Sheet-LA1.1 (page 1 of 6)

1. Provide written documentation from the owner of 5001 E Mercer Way describing the extent and duration of the access.
Written documentation from the owner of 5001 E. Mercer Way has been included with this submittal, see Authorization letters.
2. Where are erosion control measures?
Erosion control measures are demonstrated on the Wall Excavation Plan, Sheet LA2.2
3. The hardscape numbers do not match the Site Development Worksheet. Please double check and update and resubmit the plans and Site Development Worksheet as necessary. Please remember that decks count as hardscape.
The site development worksheet has been updated to the current format released by the City of Mercer Island in January of 2020. Changes are reflected on Sheet LA1.1

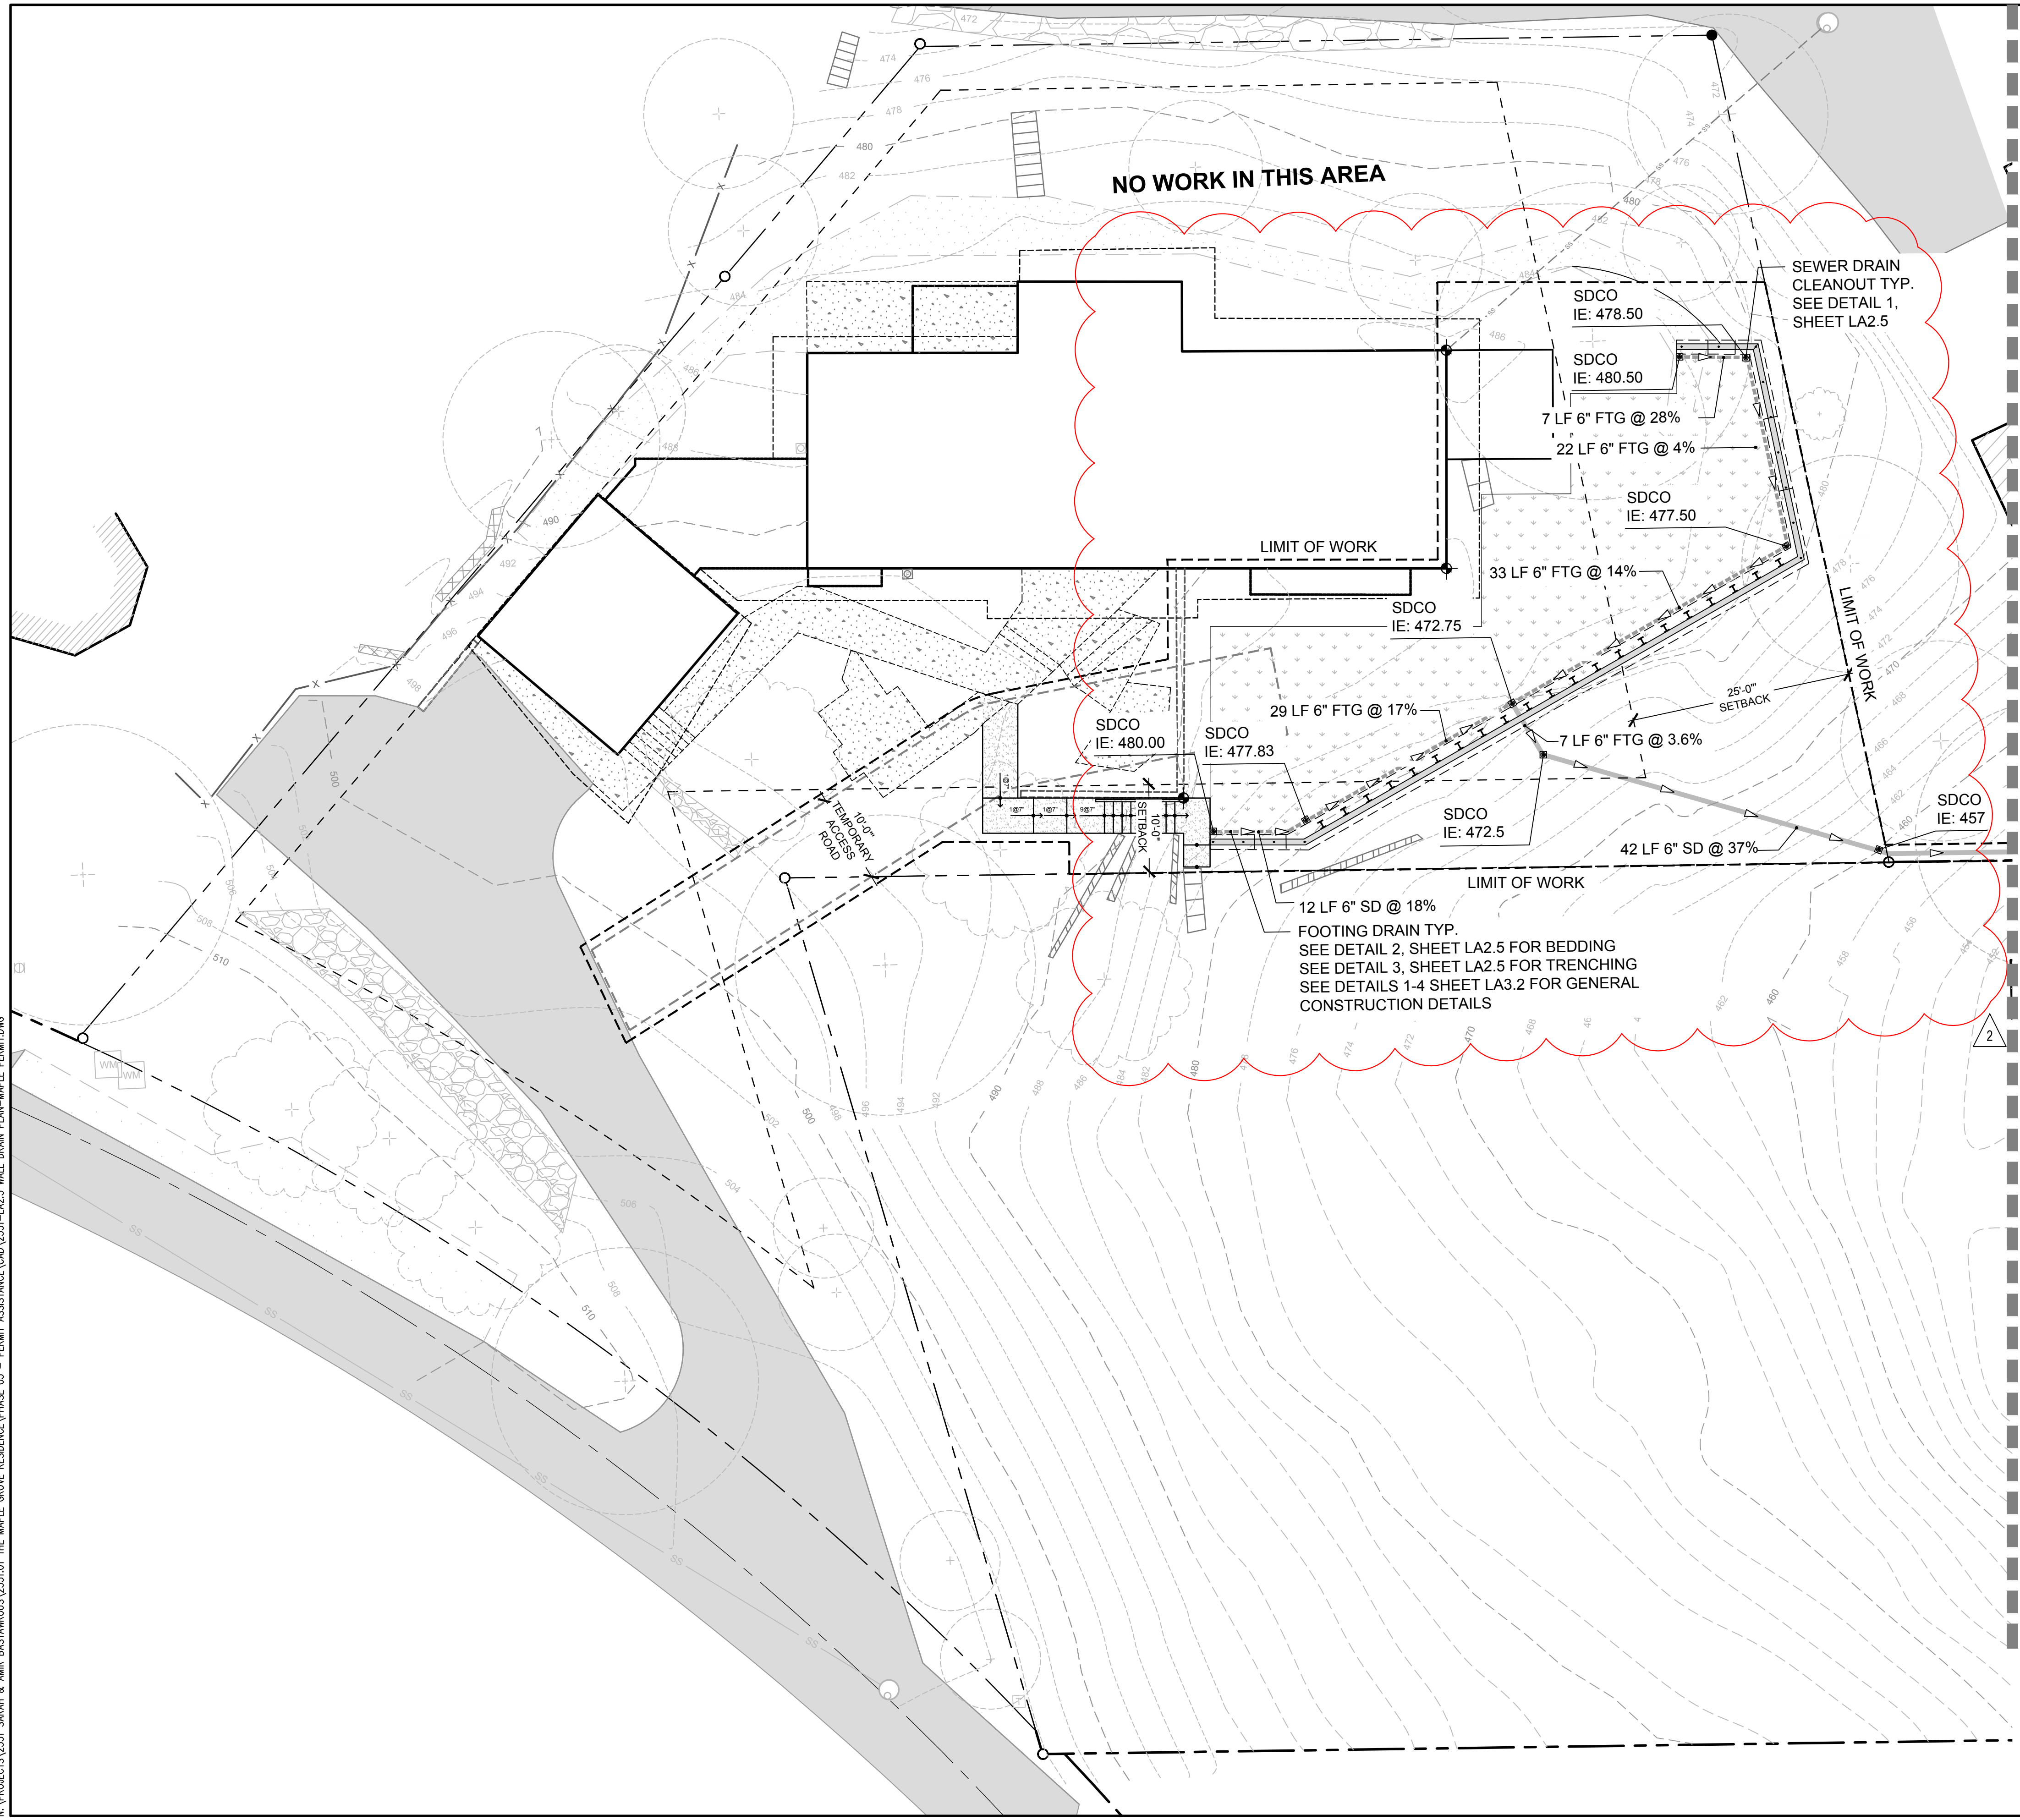
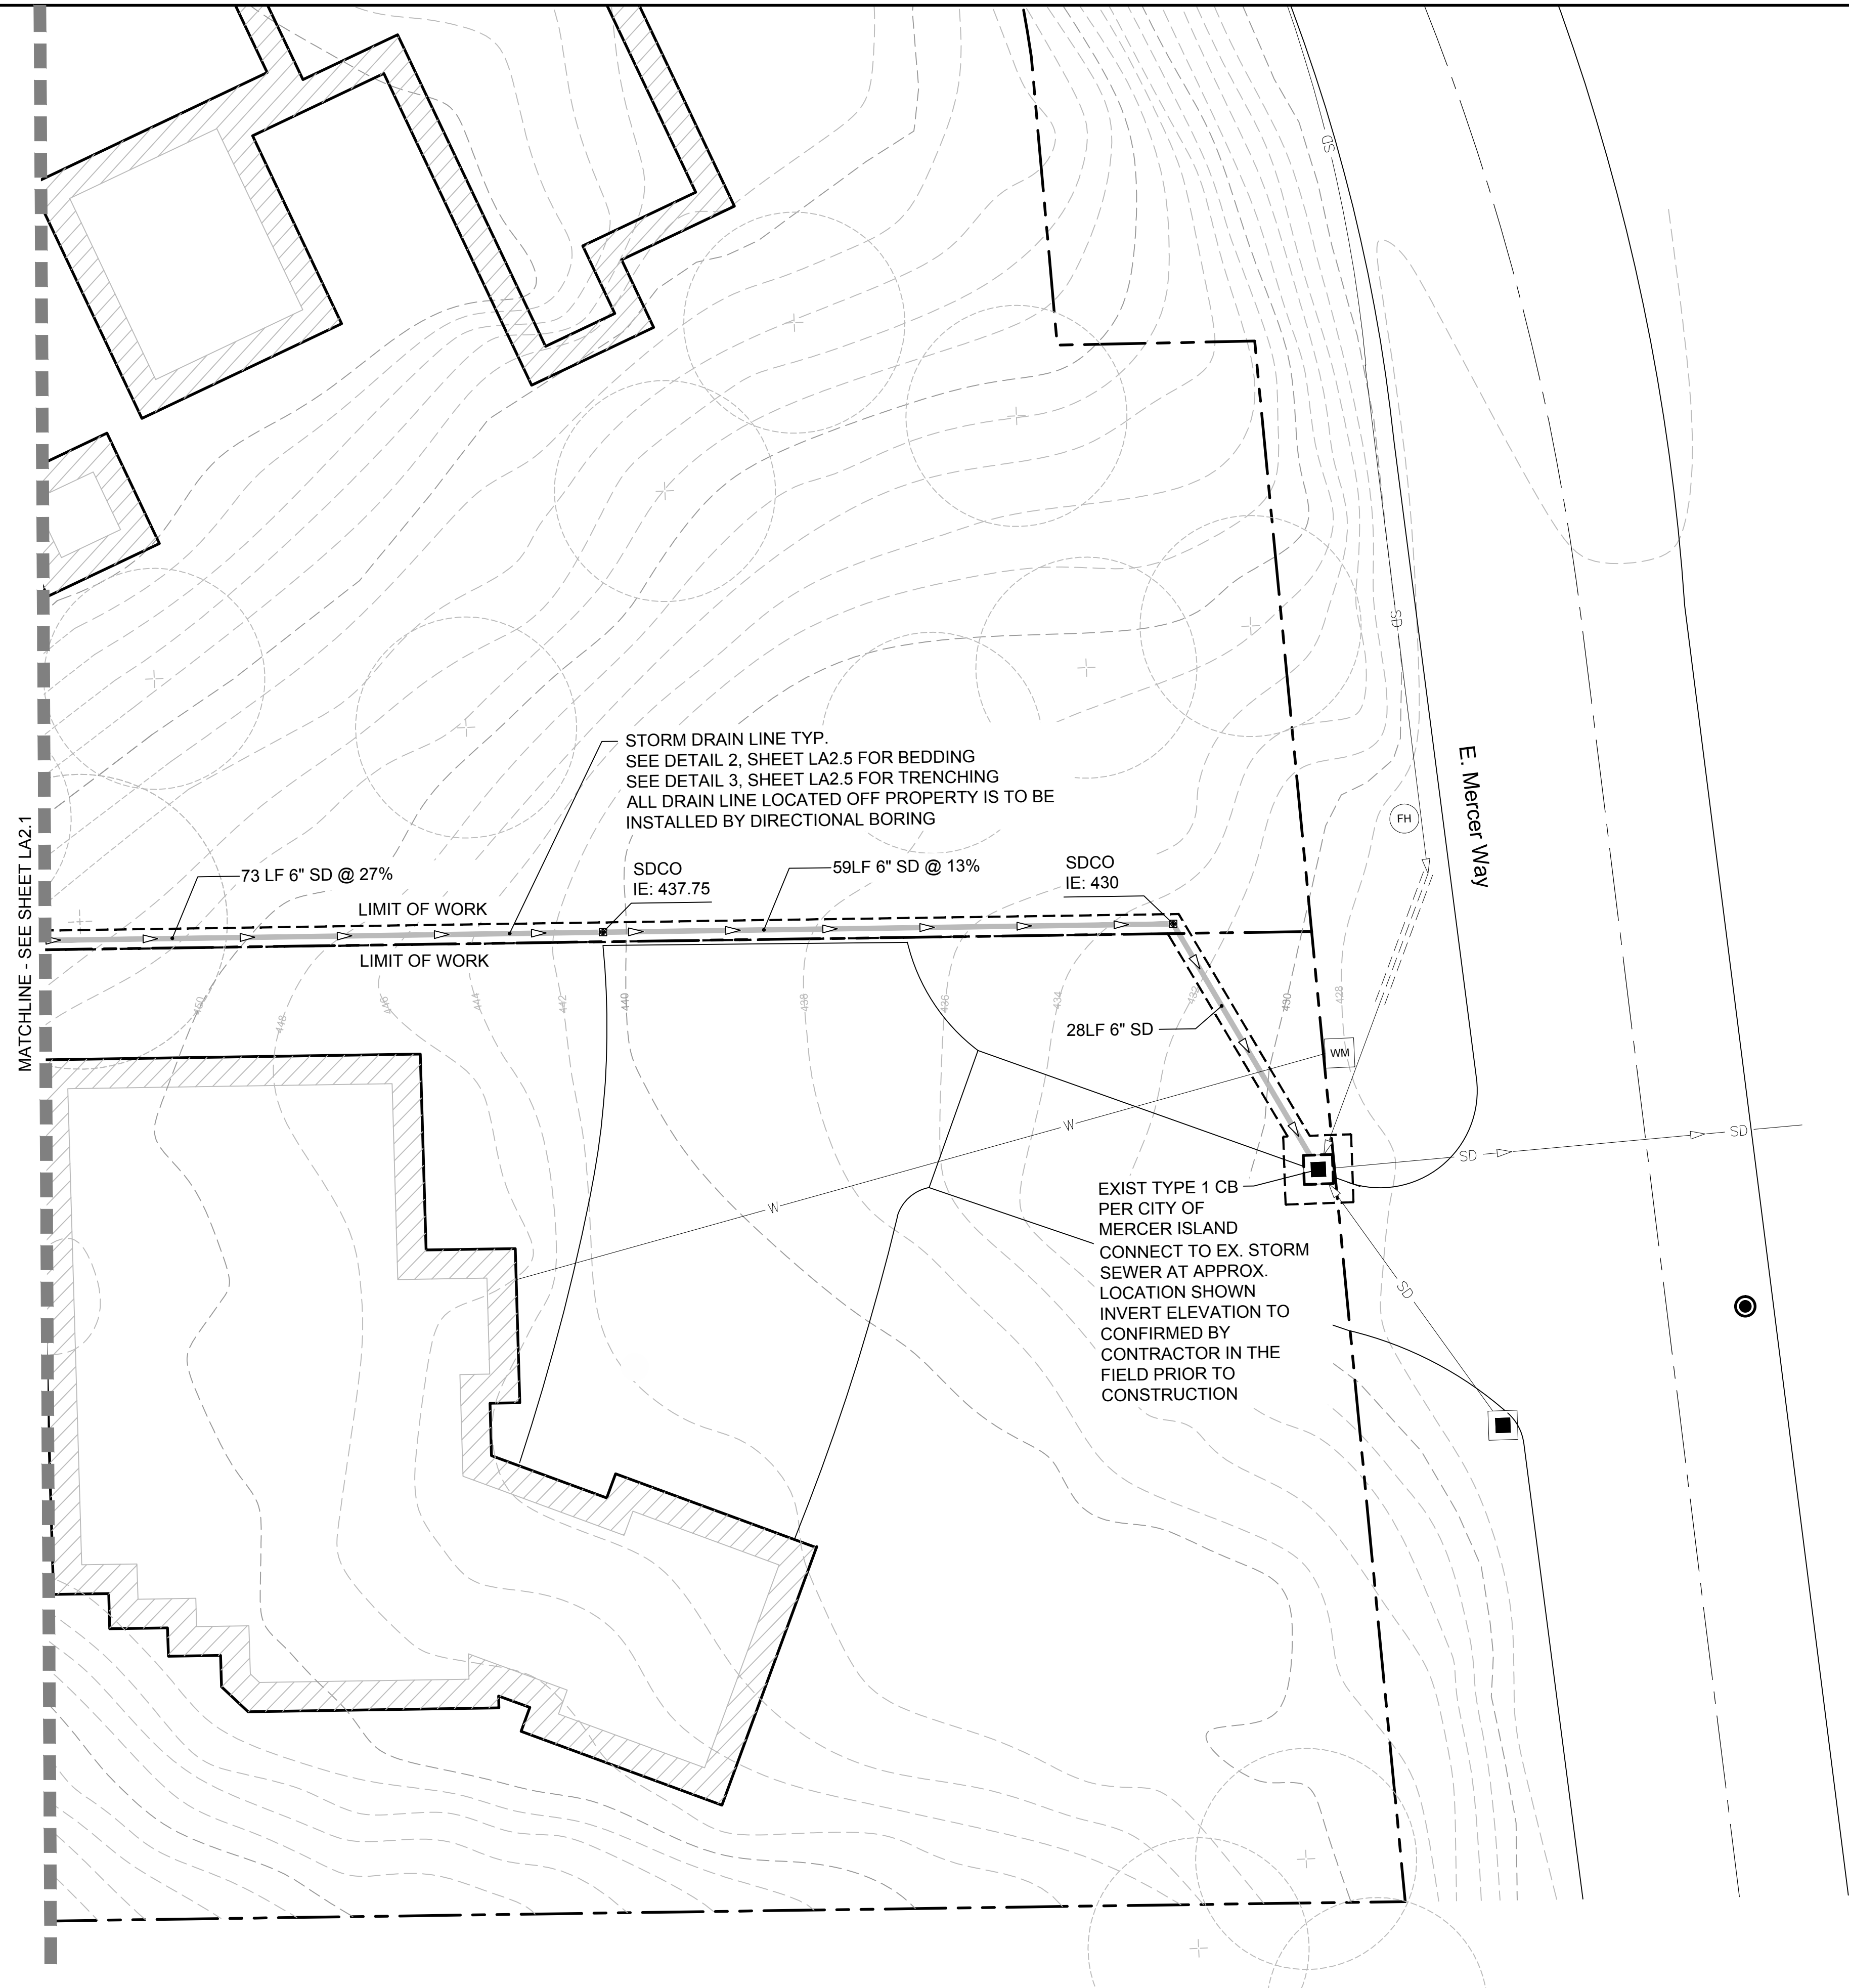
20. Wall drainage should not be allowed to exit through wall onto slope in front of wall. Wall drainage should be collected and tight lined to a controlled discharge location (not onto slopes). Revise all wall sections.
Drainage for the wall will be collected by footing drain and tight lined to the nearest storm catch basin.
Please see Wall Drain Plan and Details on Sheets LA2.3 - LA2.5

5. Draining through wall should not be allowed onto slope. Provide means to collect and discharge drainage away from slope.
Drainage for the wall will be collected by footing drain and tight lined to the nearest storm catch basin. Please see Wall Drain Plan and Details on Sheets LA2.3 - LA2.5
